PLAN-004836

27/12/2013

Proposal: Two storey extension to form bedroom and garage.
Site: 3C Fitzalan Road, Arundel, BN18 9JP.
AB/120/13/

SITE BLOCK PLAN to scale of 1:500

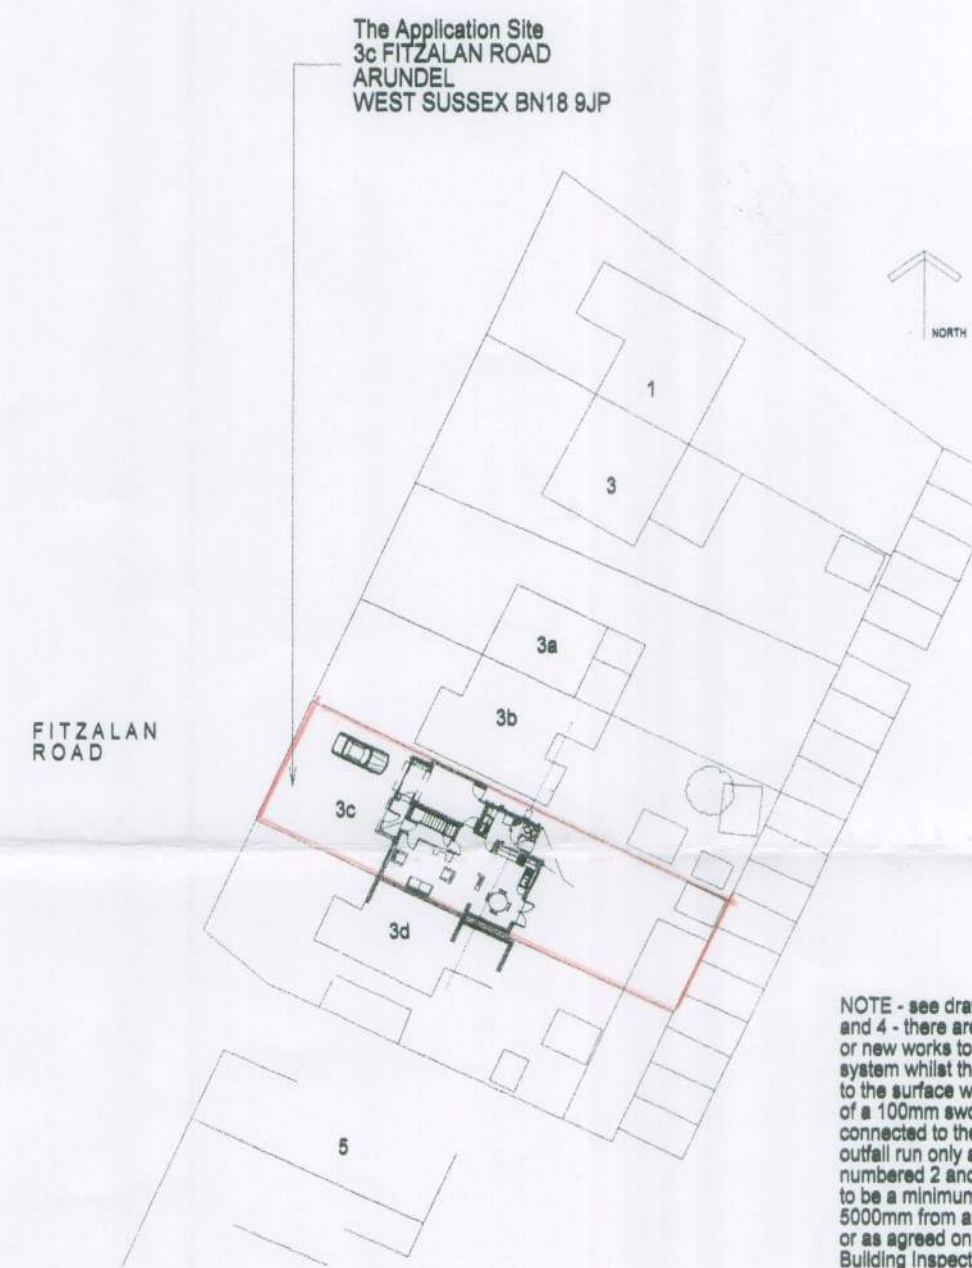
The attached plan shows that the proposed development lies close/over to an existing public foul sewer. An investigation of the sewer is required to ascertain its condition, the number of properties served, and potential means of access, before any decision can be made as to whether it would be acceptable for the proposed development close to the sewer. Part H of the Building Regulations dictates that the matter is determined by the sewerage undertaker— in this case Southern Water. The applicant is advised to discuss the matter further with Southern Water, Southern House, Sparrowgrove, Otterbourne, Hampshire SO21 2SW (Tel: 0330 303 0119) or www.southernwater.co.uk.

Our initial investigations indicate that there are no public surface water sewers in the vicinity of the site to serve this development. Alternative means of draining surface water from this development are required. This should not involve disposal to a public foul sewer.

The Council's Building Control officers or technical staff should be asked to comment on the adequacy of soakaways to dispose of surface water from the proposed development.
